OBJECTION: MIXED-USE DEVELOPMENT MACKENZIE ST, LAVENDER BAY SSD-88702457

I am the owner and resident of 12 Wilona Avenue, Lavender Bay. My home is an early 1900s single storey terrace and is identified as a contributory item within the Lavender Bay Heritage Conservation Area, it is directly across the road from the development site and is one of the properties most immediately affected by the proposed development.

June 21st 9.30am Proposed

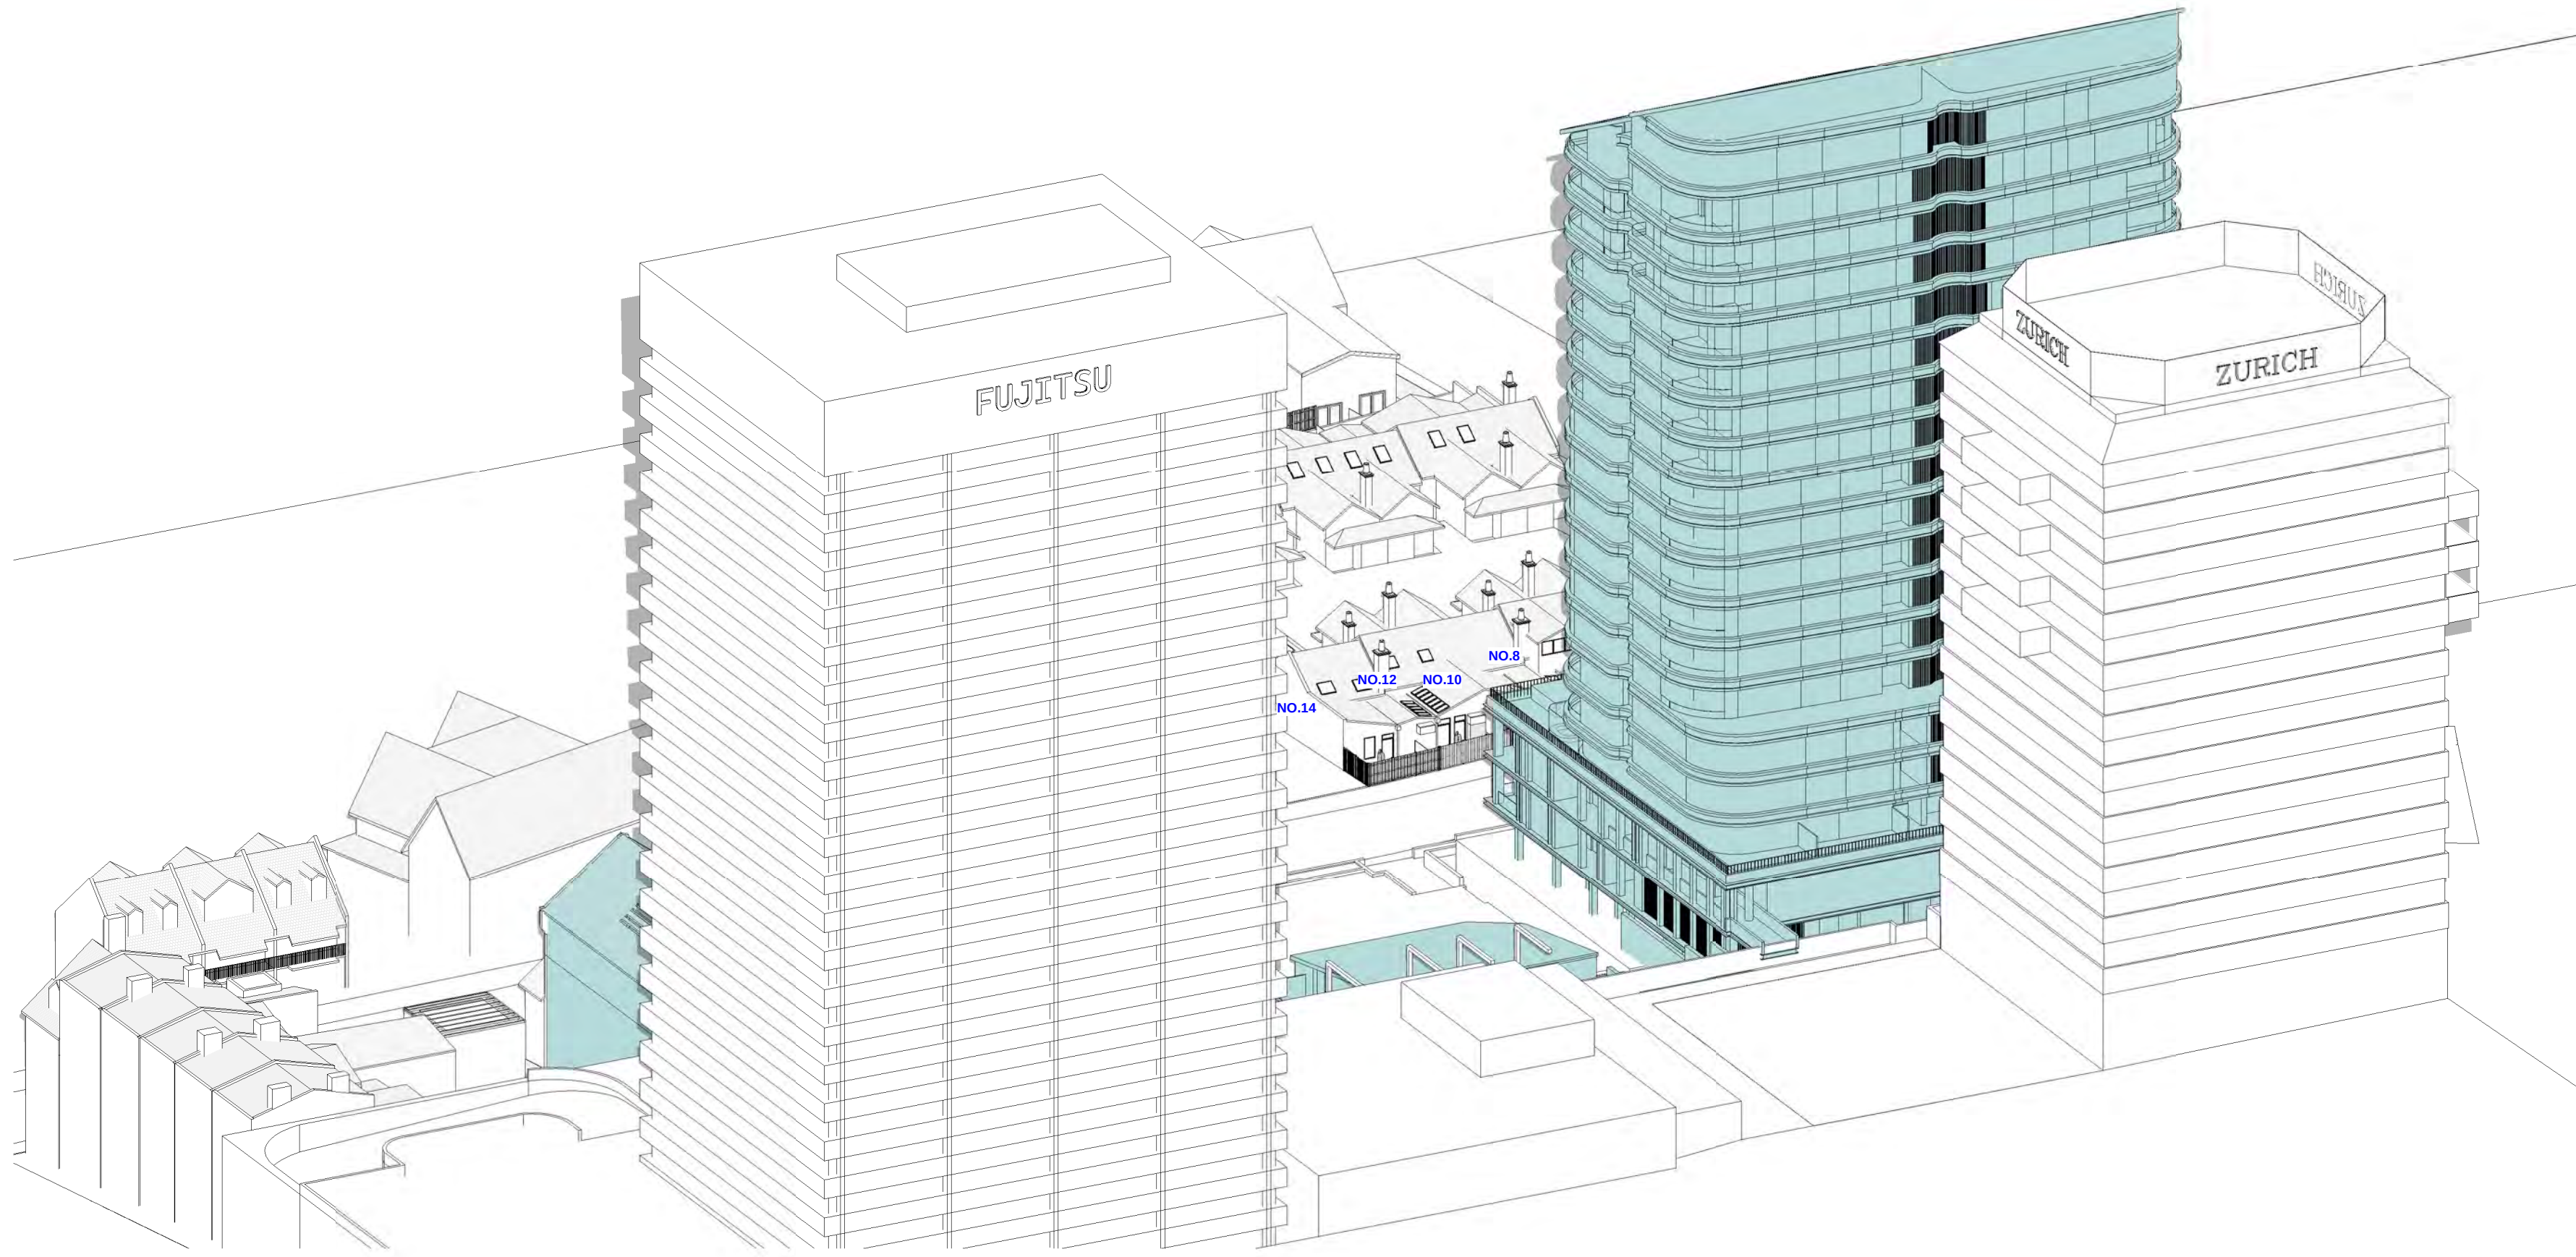
The applicant's solar assessment is not a reliable basis for determining what this proposal will do to my home and it does not show the real impact. It does not make any assessment of the solar impact on my home, assuming incorrectly that we currently have no solar access therefore disregarding the impact. It also omits the existing solar panels on my roof. My independent analysis looks at the actual openings to my home, hour by hour, and compares existing solar access with what will remain after the development. The result is clear: substantial existing sunlight will be taken away.

Most importantly, the applicant's own overshadowing diagrams demonstrate that the severe solar impacts identified above are not an inevitable consequence of redevelopment of the site. Appendix L shows that development within the existing planning controls would cause substantially less additional shadow and only minimal overshadowing of the Wilona Avenue terraces and my home.

Equinox 9.00am Existing

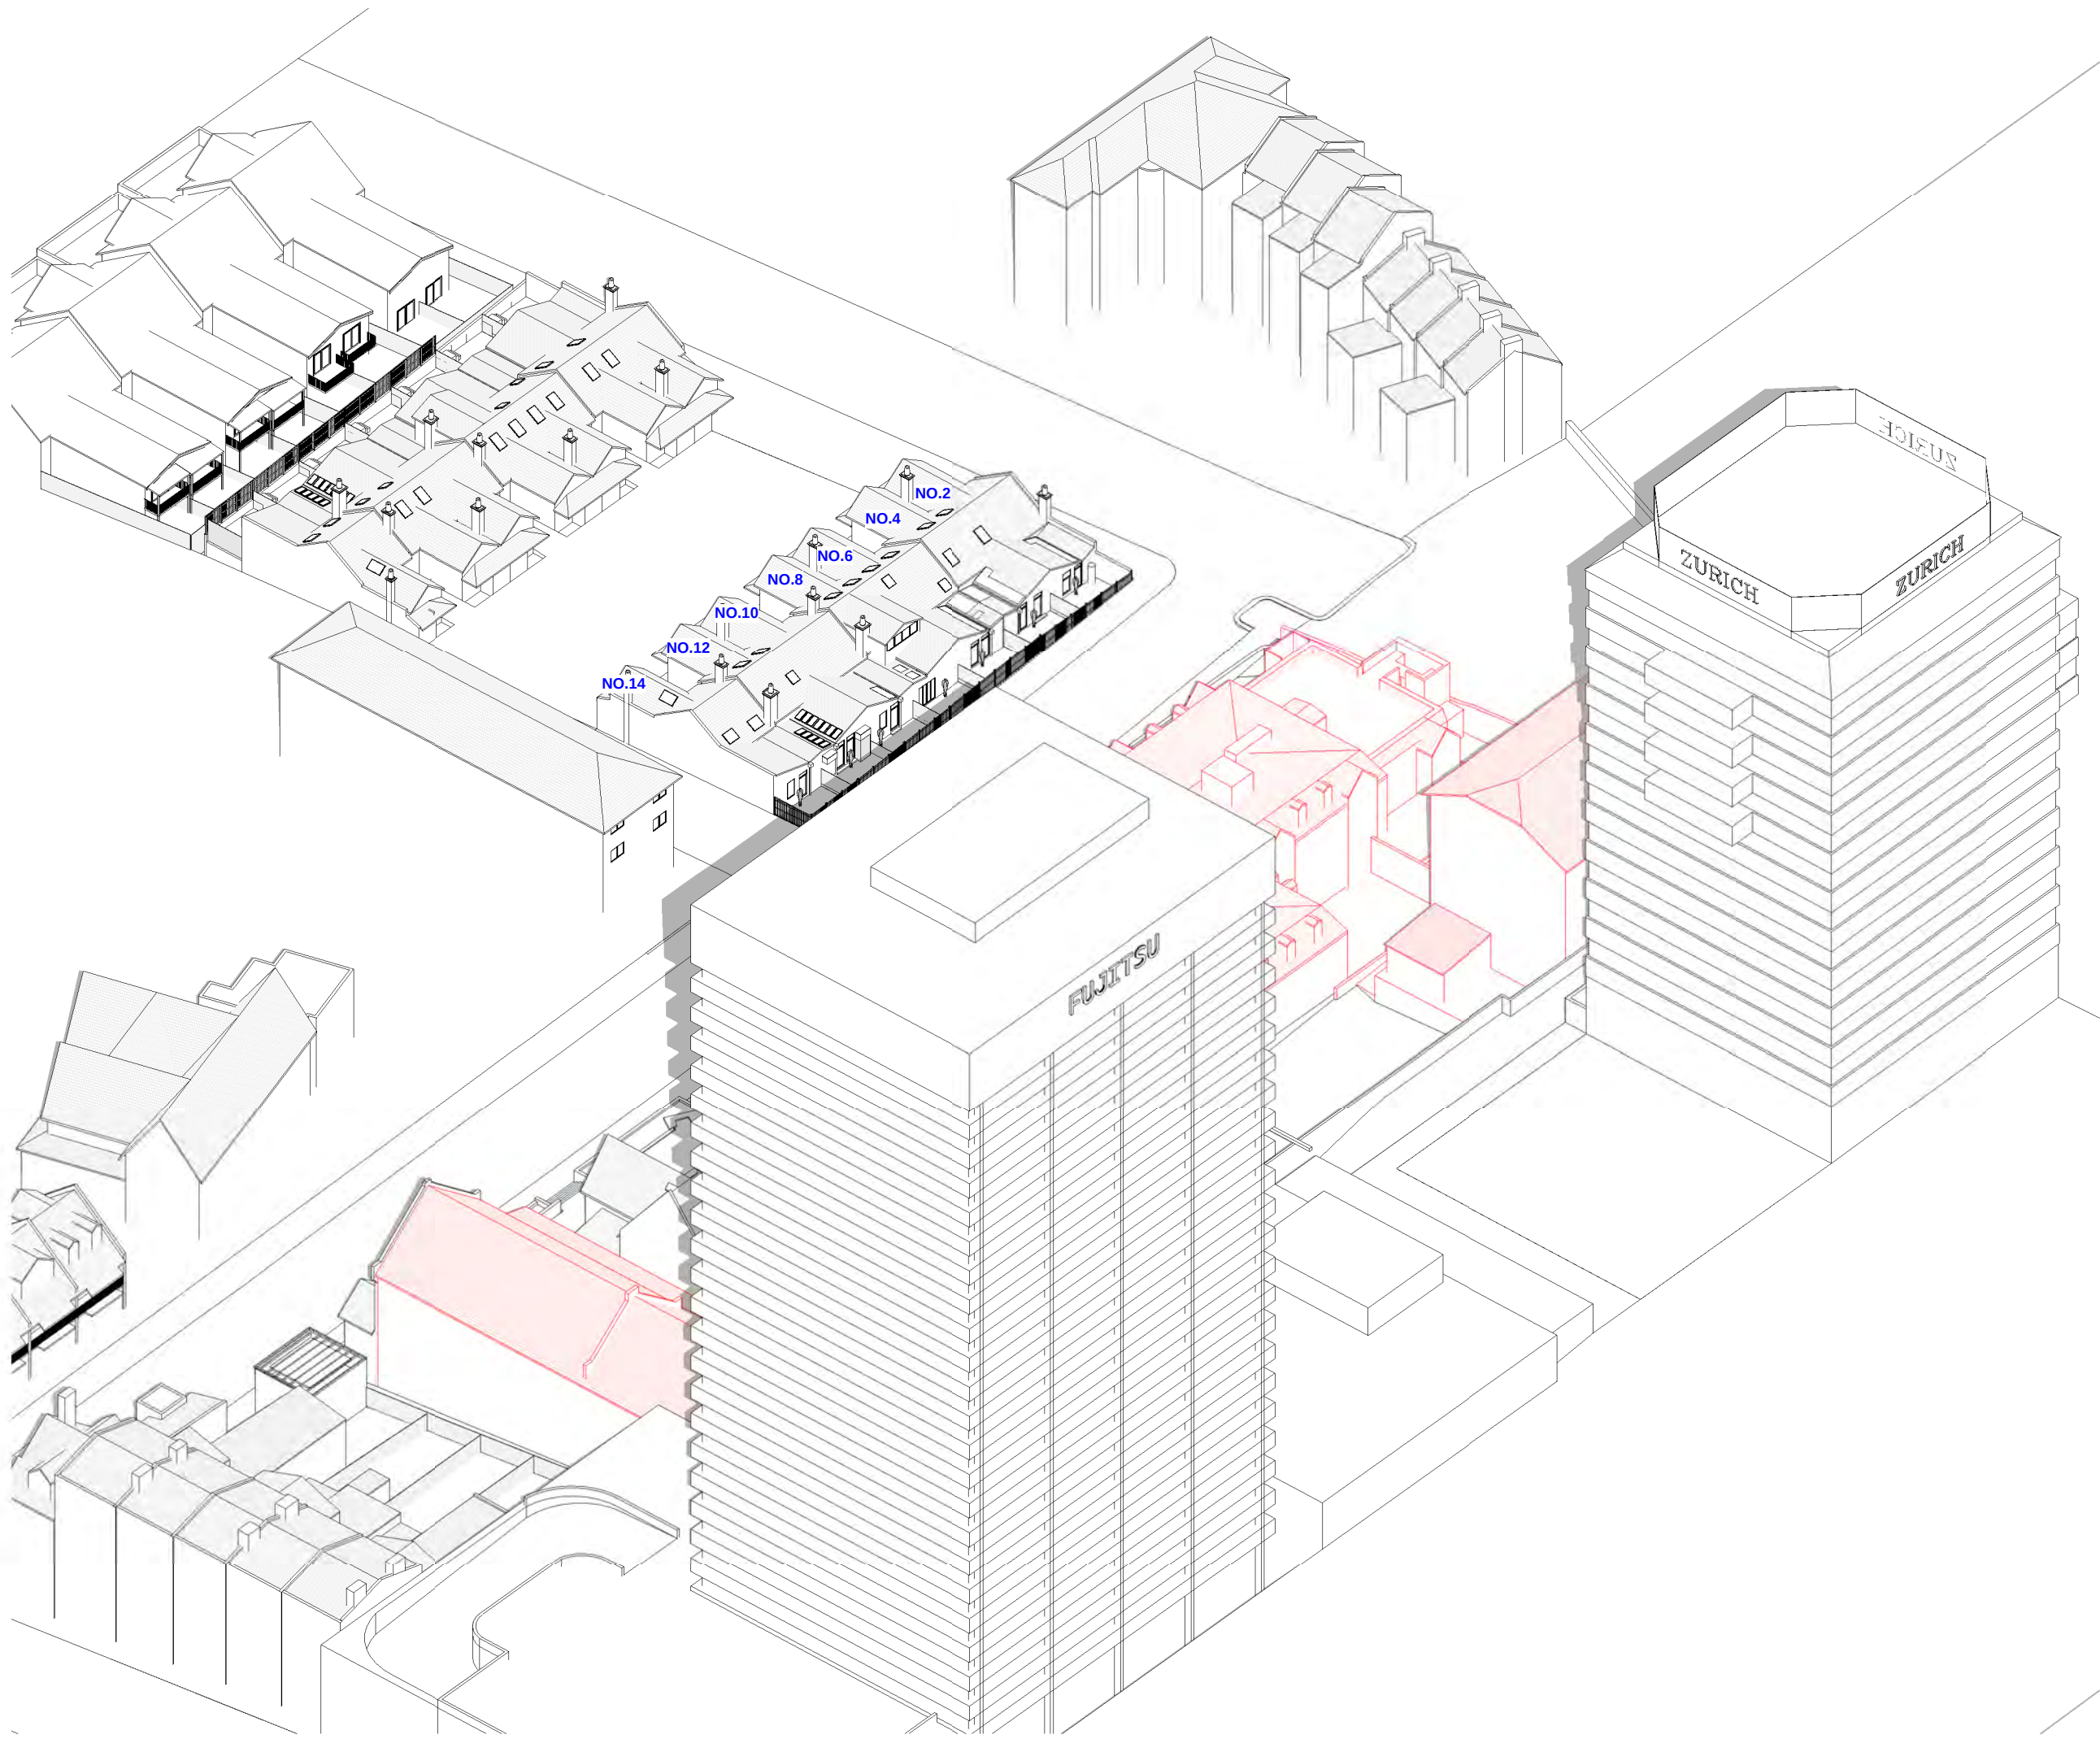
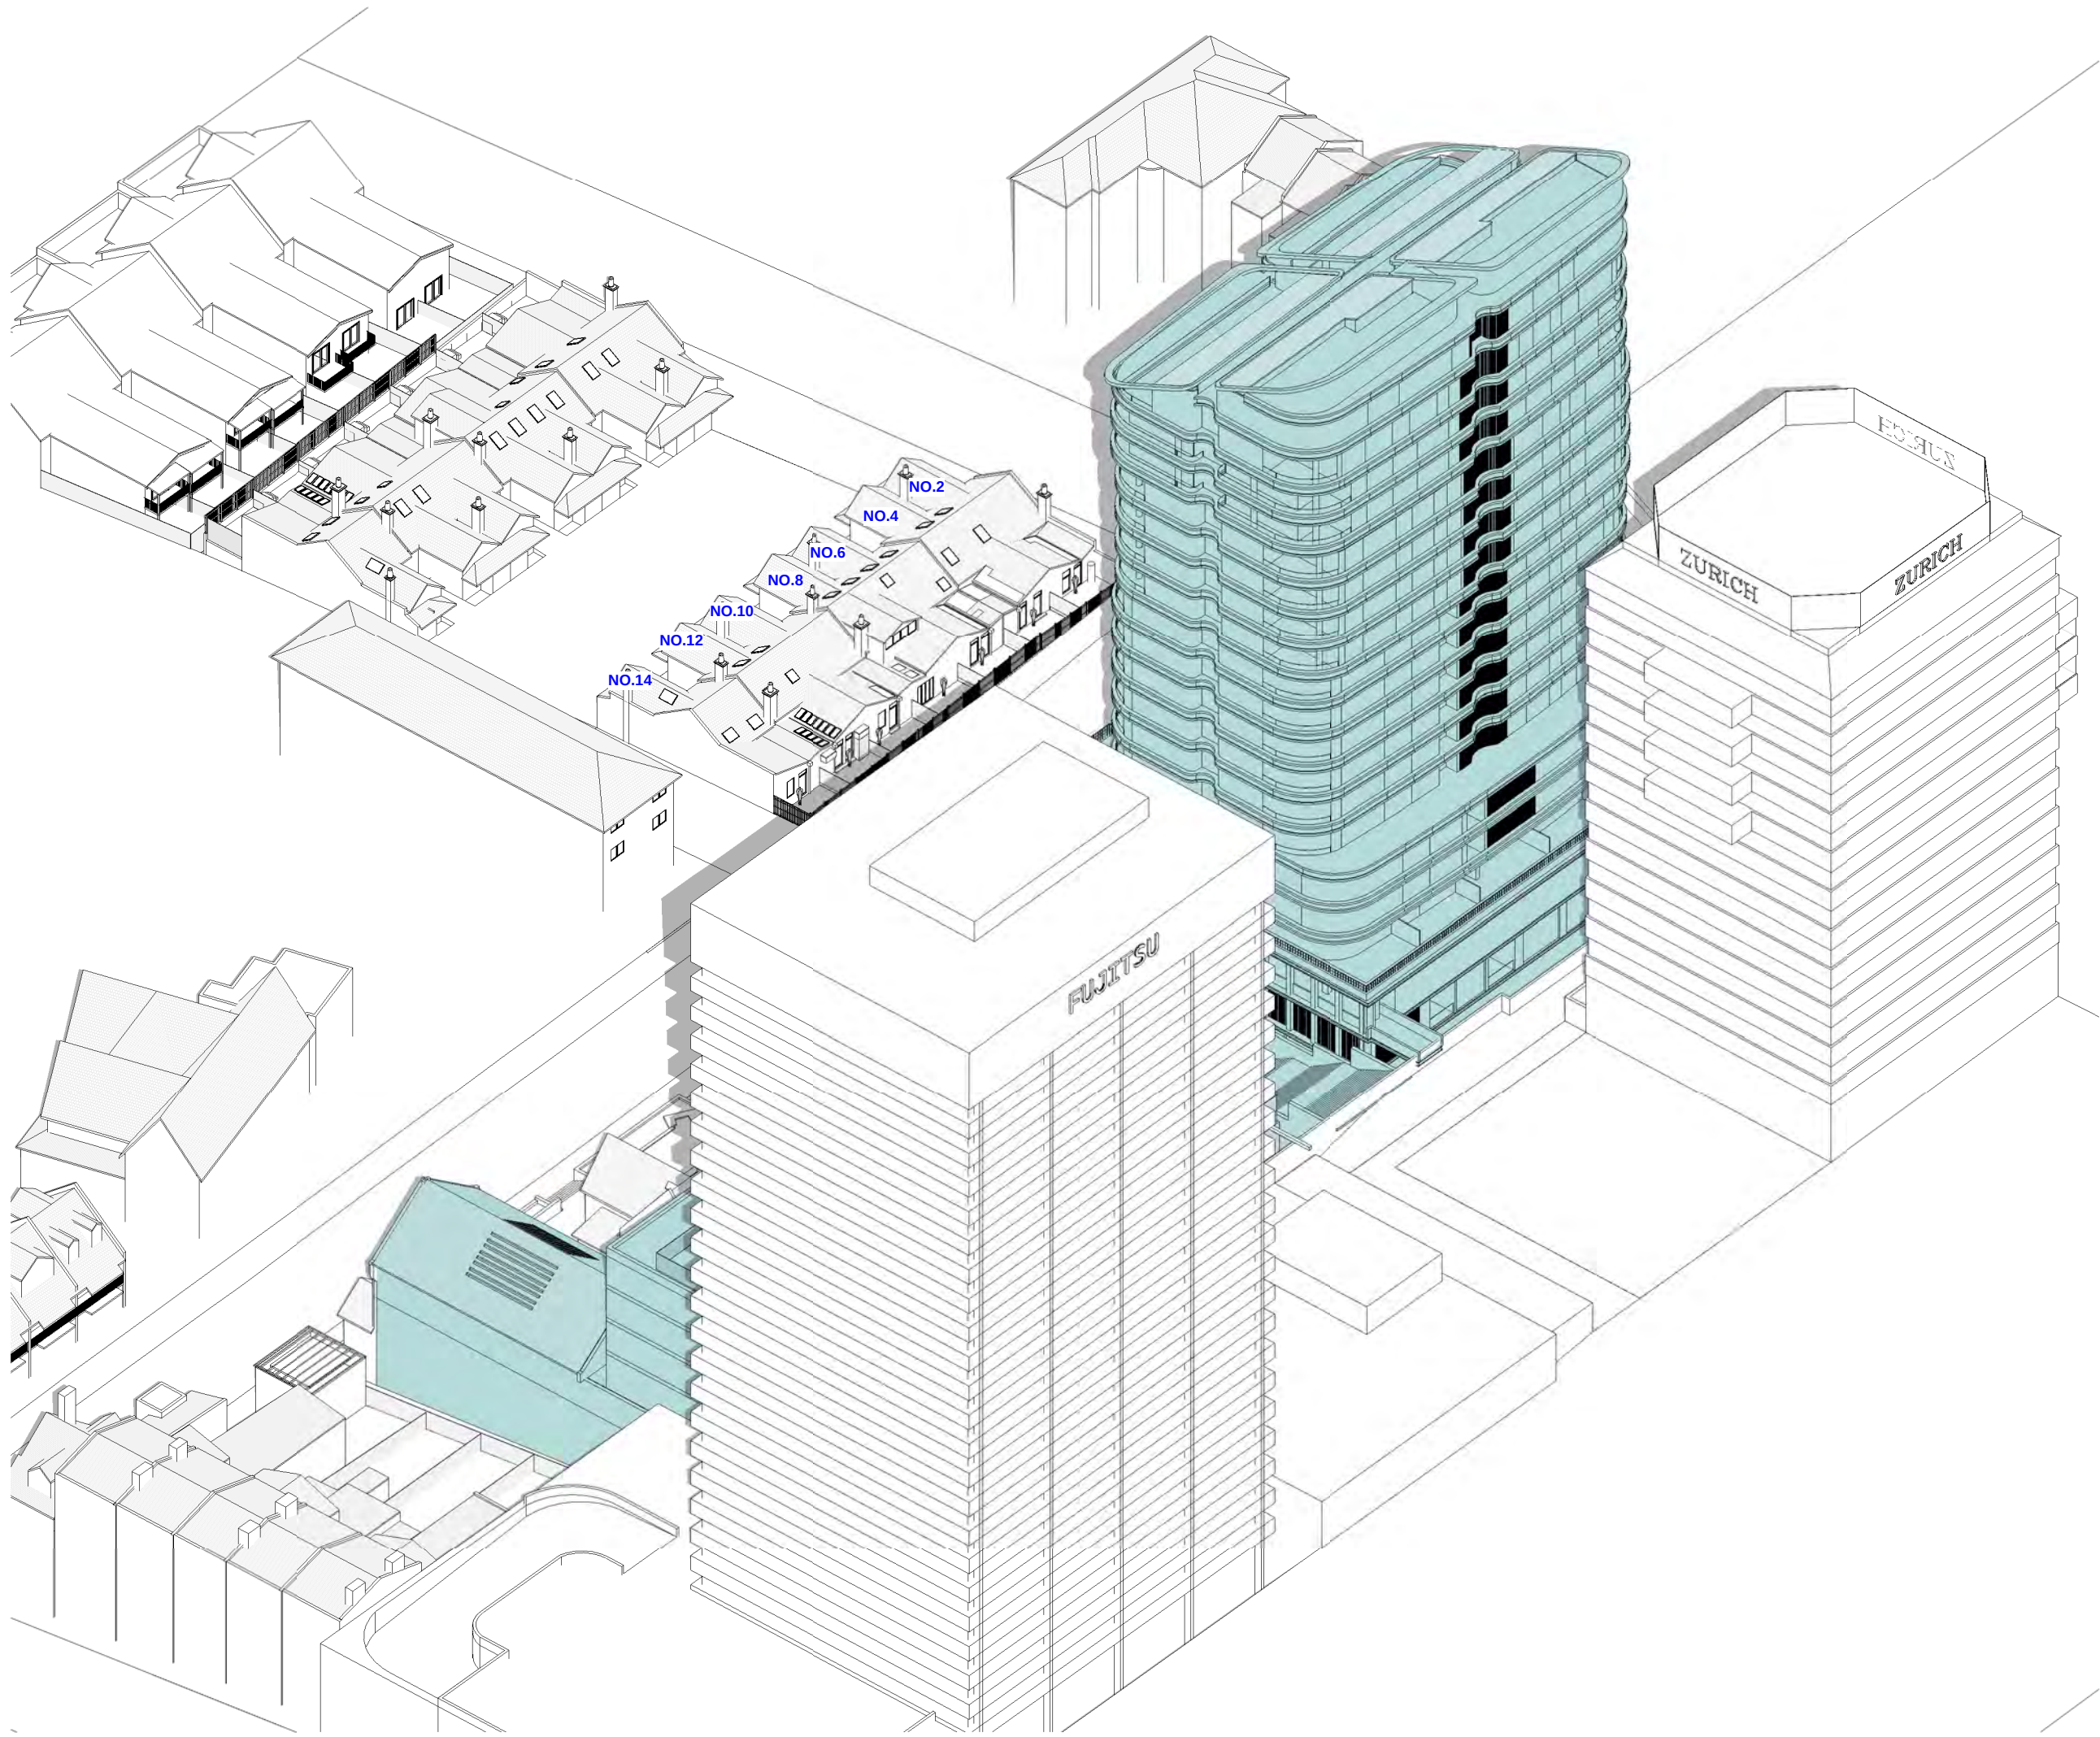
There is also a broader problem with concentrating the assessment on the winter solstice, when considering the impacts of a building of this height, mass and scale in such close proximity to a low-rise terrace house. The impact extends well beyond the winter solstice. The independent equinox modelling compares the existing and proposed conditions hourly between 9.00am and 3.00pm and demonstrates that the proposed tower continues to create additional overshadowing of the Wilona Avenue residential area during the equinox period.

This is significant because the equinox represents a time of year when the higher solar angle should provide substantially greater access to sunlight than in mid-winter. A development of this scale should not extend substantial additional overshadowing of neighbouring homes into the equinox periods.
